Our Ref: 24/00269/HFUL
Your Ref: 54 South Rd CB24 9PN

**South Cambridgeshire District Council
Application for Planning Permission**

Proposal: Two storey side extension.

Site address: 54 South Road Impington Cambridgeshire CB24 9PN

Proposed Section AA6

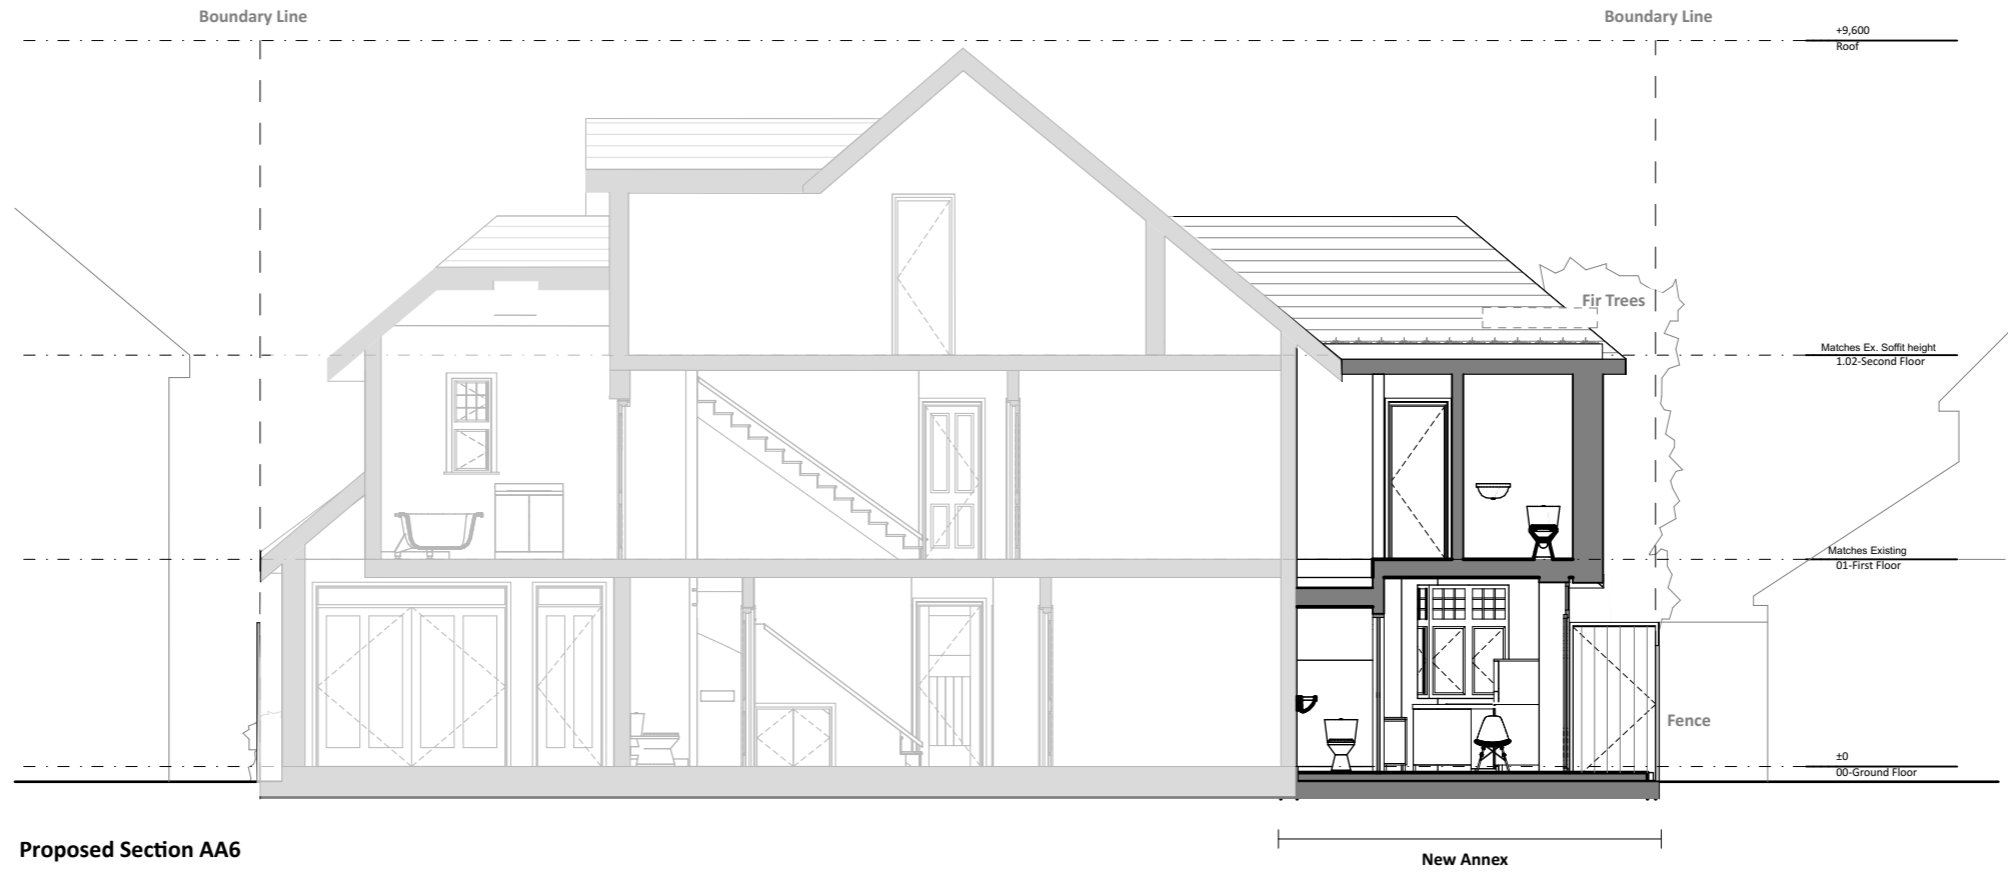
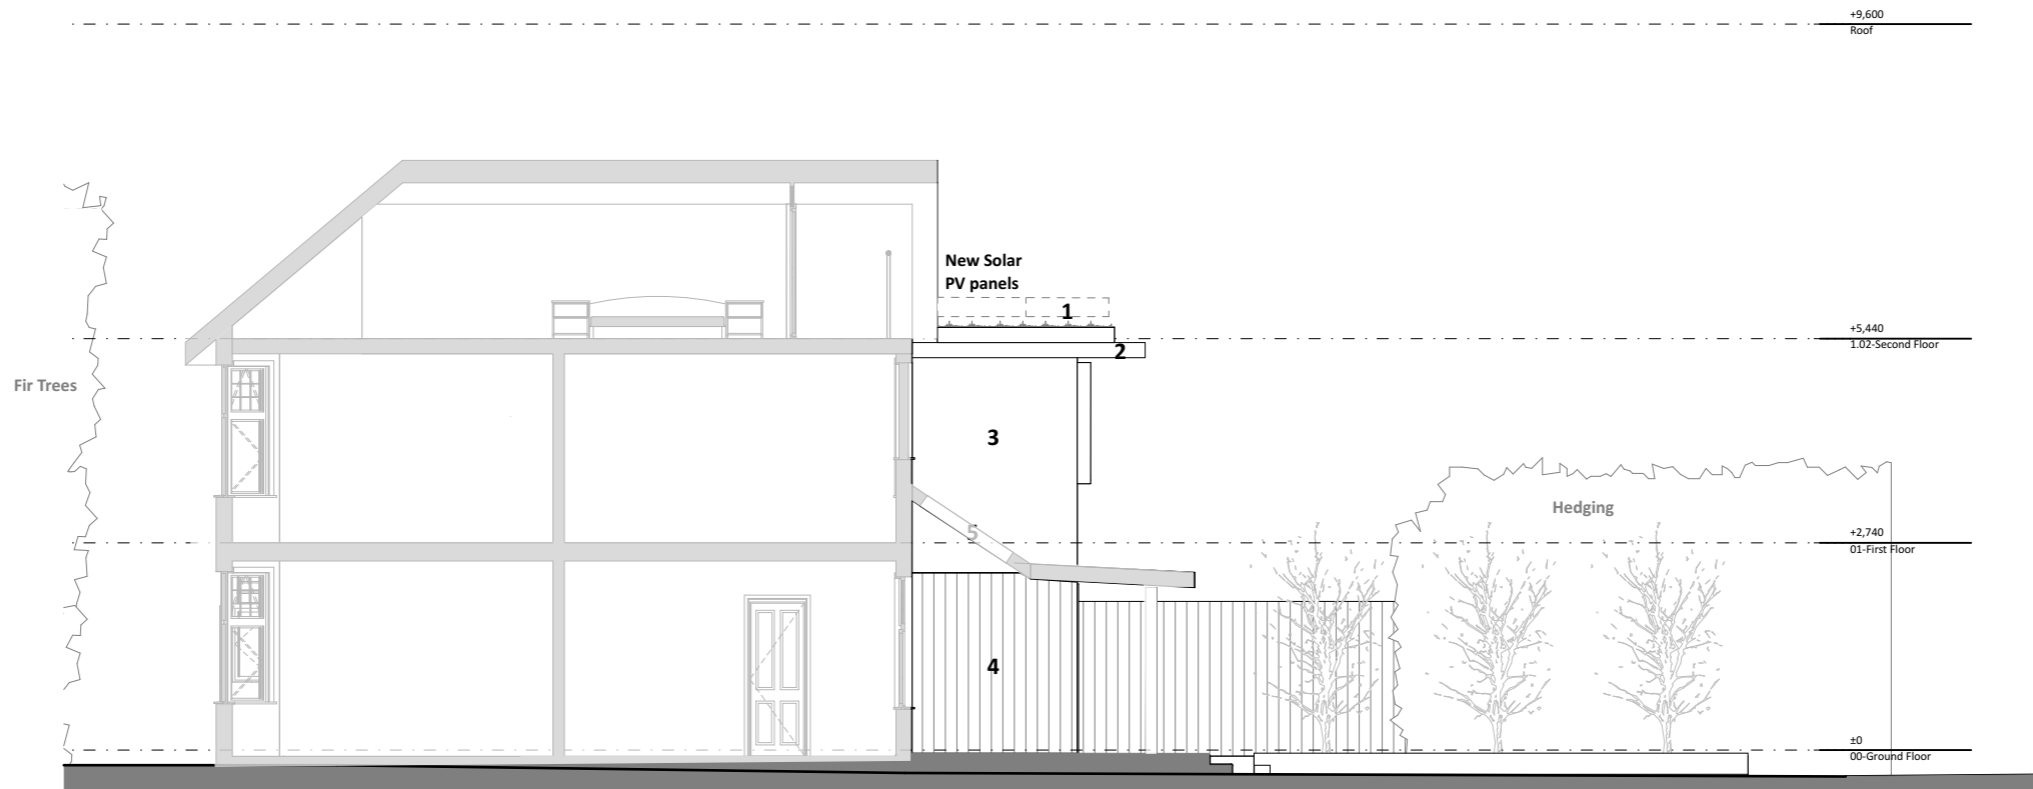
1. Please confirm that you are agreeable to the proposal being amended to: 'Two storey side extension'.
2. Please provide a location plan with the whole site outlined in red.
3. Drawing numbers 100 141 (proposed elevations) and 100 160 (proposed sections) both refer to existing on the actual drawing. Can you please amend and resubmit.
